**Growth and Sustainability
Regeneration and Culture
Planning and Building Control**

Ref: 2025/0554
Date: 23rd October 2025
Enquiries Jess Duffield
Direct 01226 772589
E-Mail: jessicaduffield@barnsley.gov.uk

**RE: Discharge of conditions 3, 4, 5, 6, 7, 8, 9, 10, 11 and 17 of app 2024/1000:
Erection of 2no. two-storey residential blocks for use as assisted living
accommodation, consisting of 14no. apartments across the two blocks with
shared amenity space, parking, cycle storage and bin stores, with associated
highways/access works.**

**DRAWING TITLE** PROPOSED ACCESS WORKS

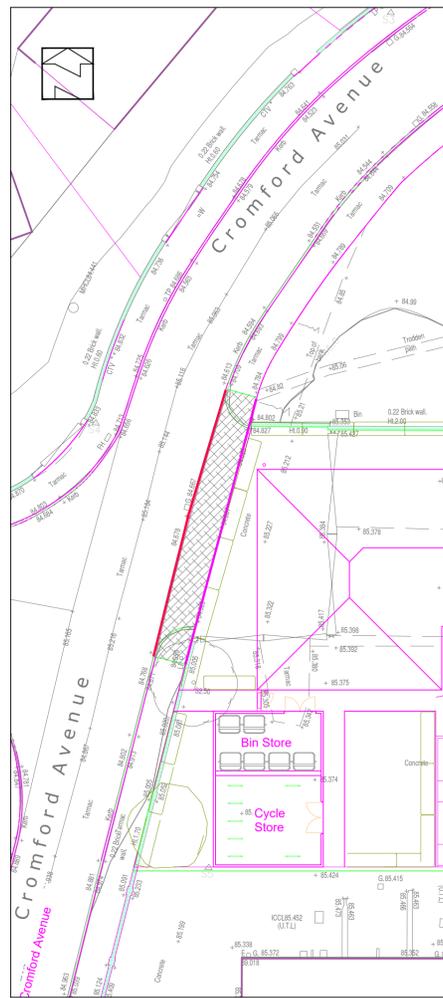
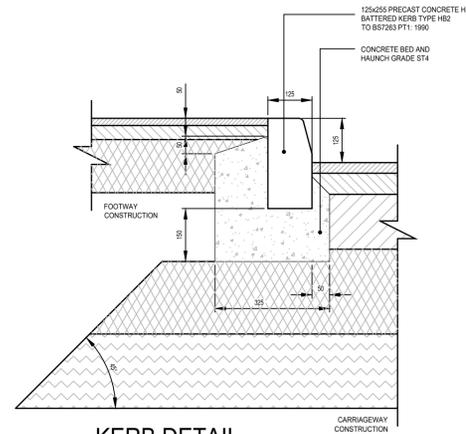
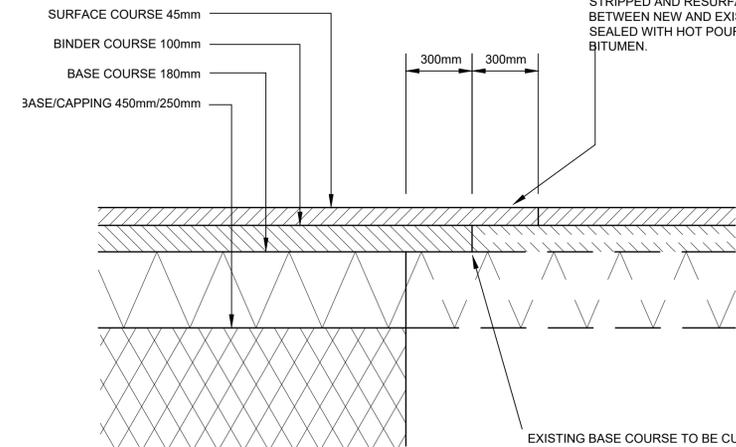
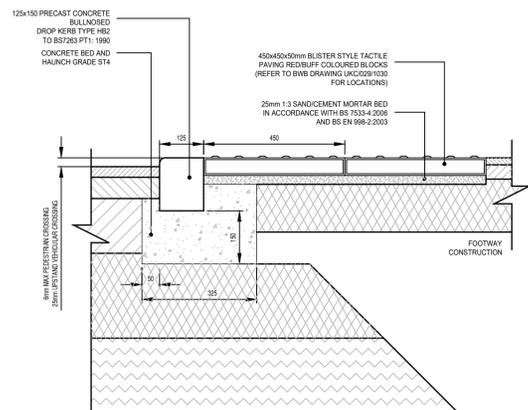
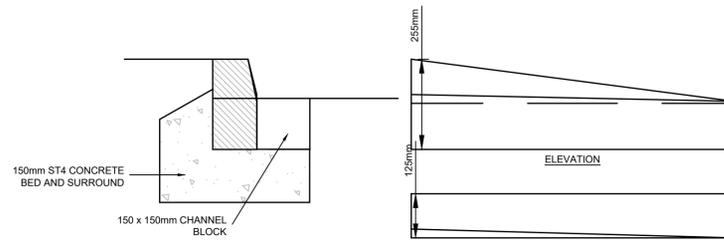
The Highways DC Officer has reviewed the submitted highways details in relation to the S278 works. These have been altered to include a vehicle crossing with full footway (drawing ref: 25359- DR-C-0800, Rev: P2, received: 30/9/2025), rather than the originally proposed 'bell mouth'. The condition is discharged in part, with evidence to demonstrate that the works have been implemented in accordance with the approved details required in order to fully discharge the condition. Photographic evidence should be submitted to and approved in writing by the Local Planning Authority prior to occupation. The applicant is reminded that no highway works can commence until the Streetworks licence has been granted.

Drawing: Proposed Site Plan covering Discharge of Conditions
Drg No: 13

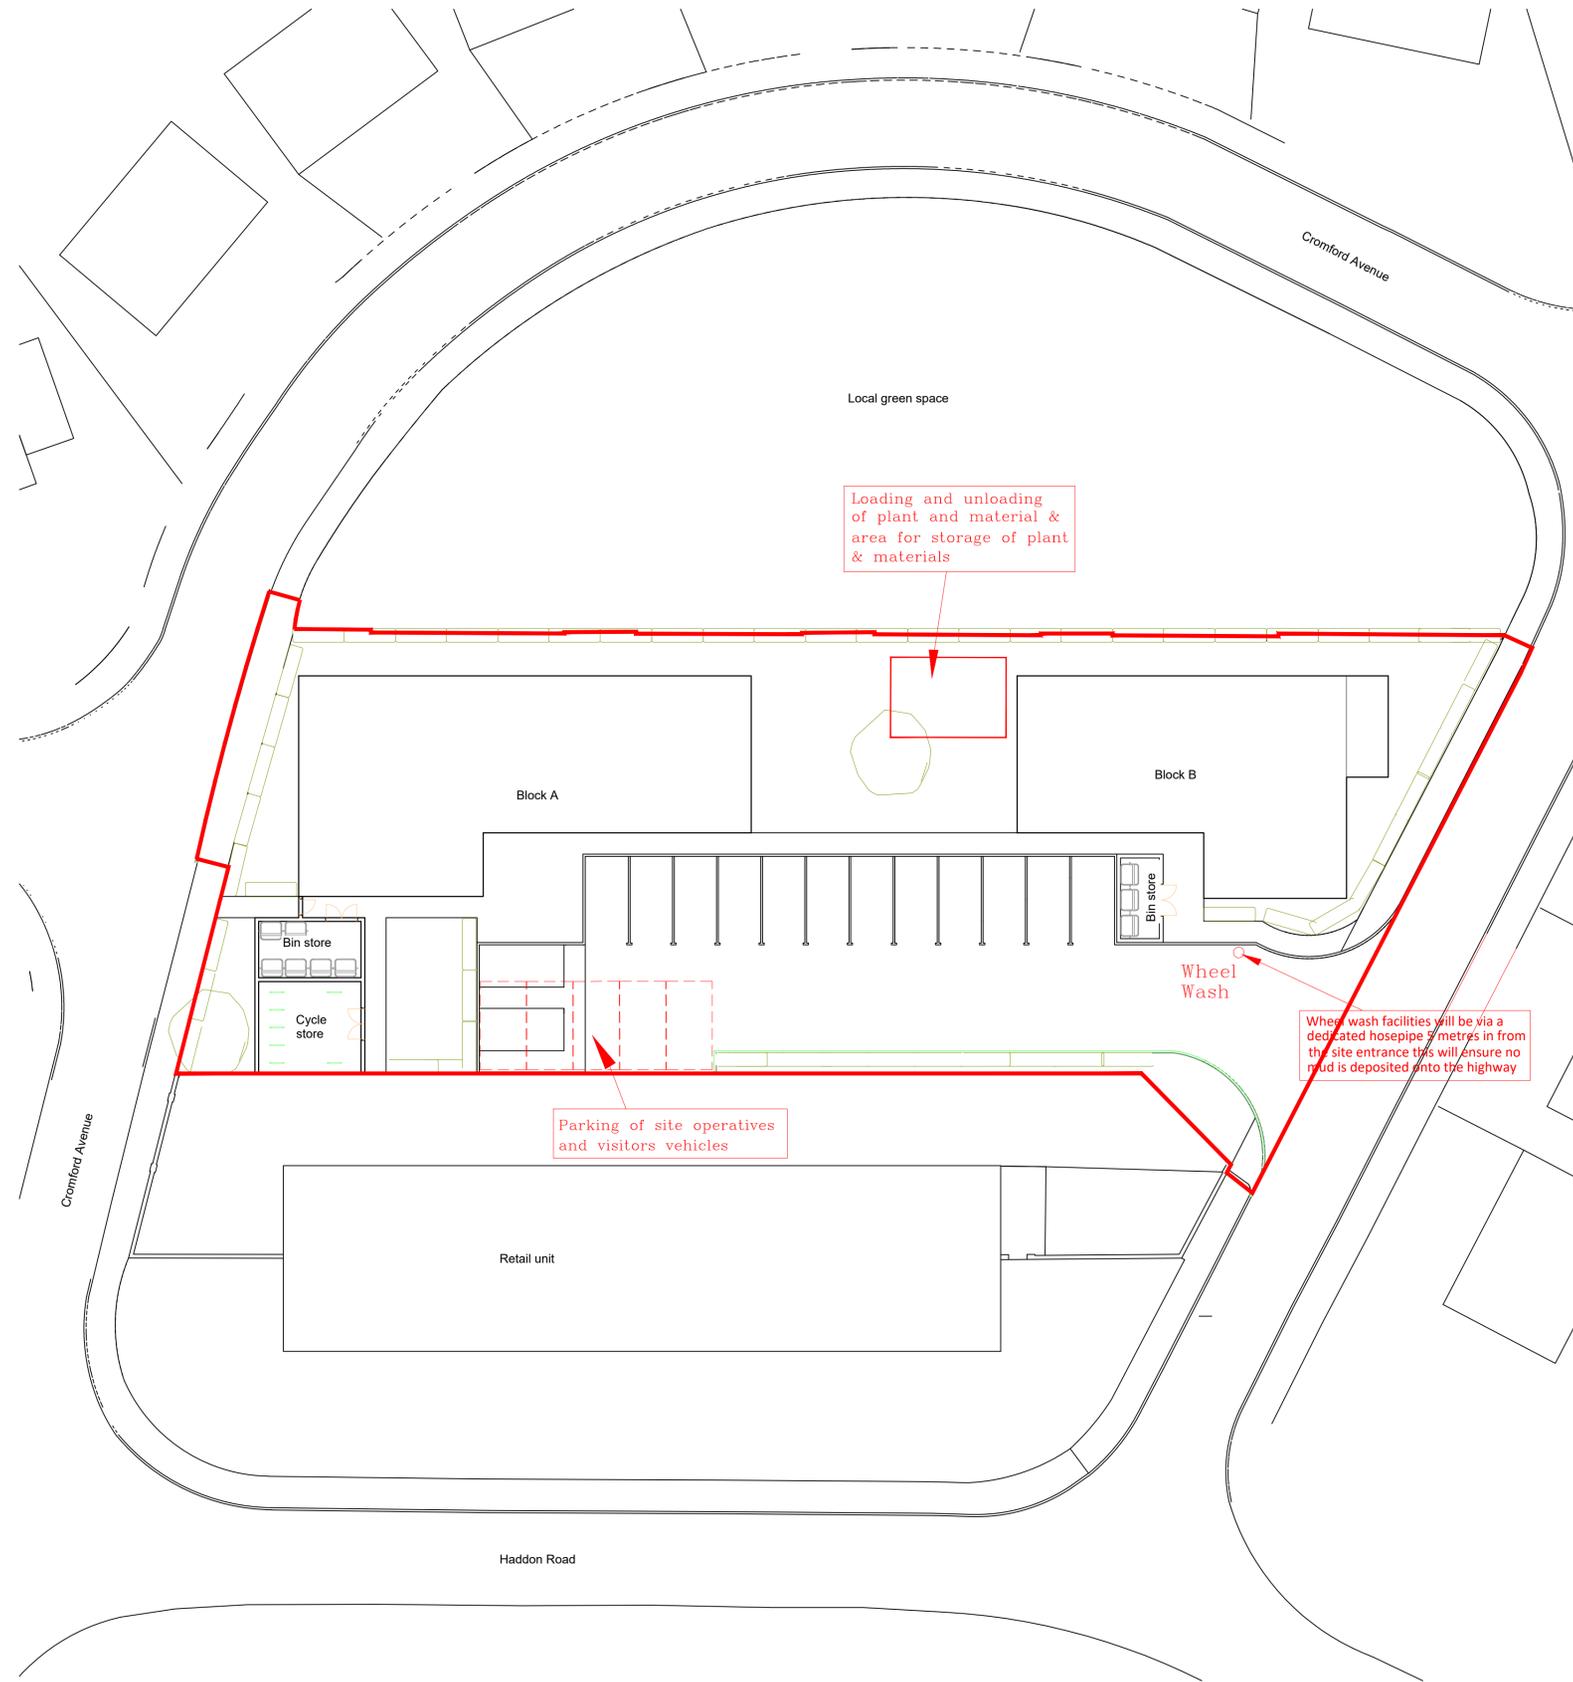
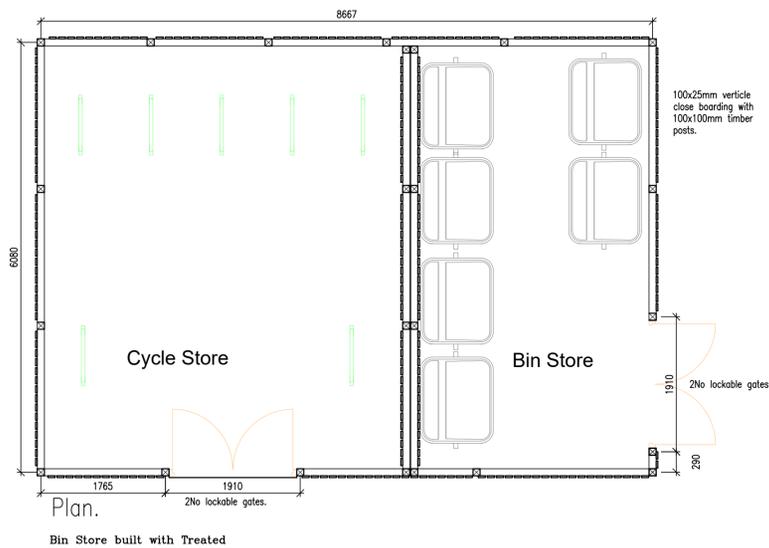
The proposal has been amended so that the cycle and bin store building(s) have roof enclosures, as requested by the Urban Design Officer. This is shown on submitted drawing number: 2563 13, Proposed Site Plan, Rev B, received: 1/9/2025. The Urban Design Officer confirms that the submitted details satisfy the requirements of the condition, which is therefore discharged in full.

The proposal has been amended so that the cycle and bin store building(s) have roof enclosures, as requested by the Urban Design Officer. This is shown on submitted drawing number: 2563 13, Proposed Site Plan, Rev B, received: 1/9/2025. The Urban Design Officer confirms that the submitted details satisfy the requirements of the condition, which is therefore discharged in full.
